**TO:** Jonathan Humbert  
**PROJECT #:** 23-1872-A  
**PAGE:** 1 of 1  
**DATE:** January 28, 2025  
**LOCATION:** NC 55 East, Erwin NC  
**PLAN REF:** Humbert Residence by K&A Home Design  
Project# 23-1872-A

**THE FOLLOWING CHANGE(S) OR PROPOSED CHANGE(S) LISTED BELOW ARE DEVIATIONS OR CLARIFICATIONS FOR THE ABOVE REFERENCED PLANS:**

S-2

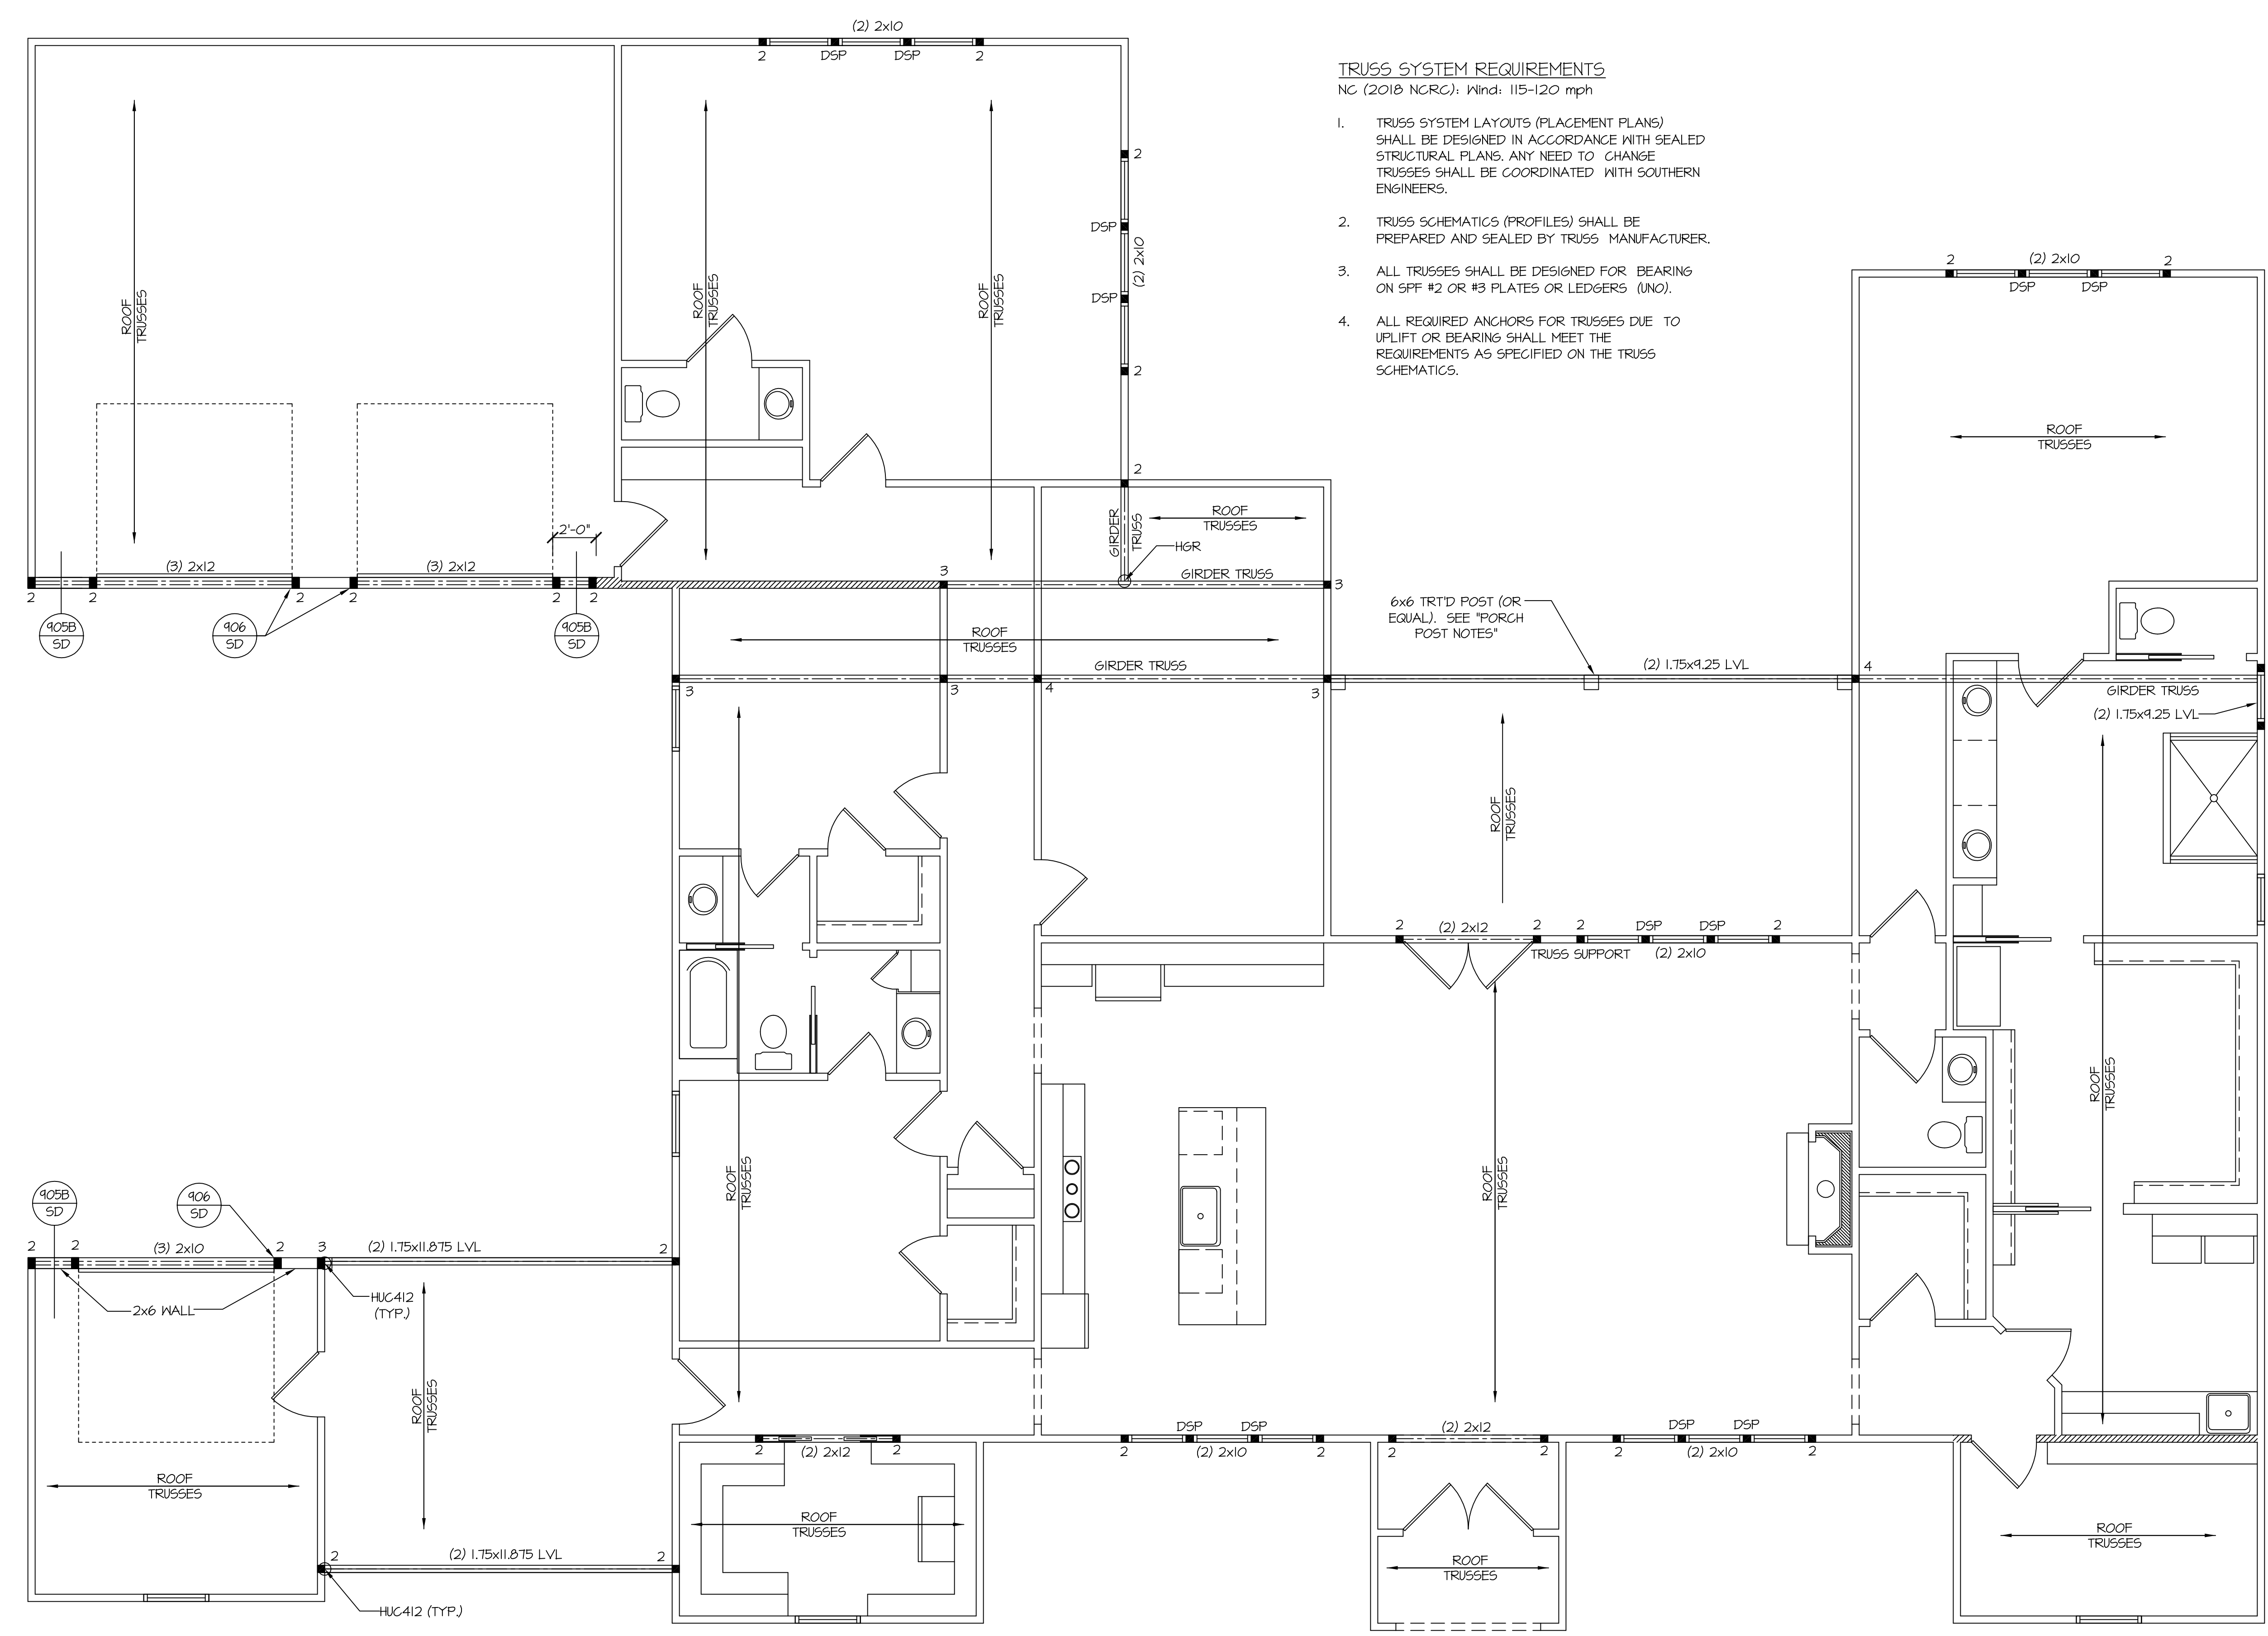
Garage Wall Studs: Per information provided by the builder the Garage walls are 10'-10" tall which exceeds the code limit of 10'. The Garage walls are framed with 2 x 4 @ 16" OC.

**Response:** The Garage walls described above are acceptable provided that an additional stud is added to every third stud.
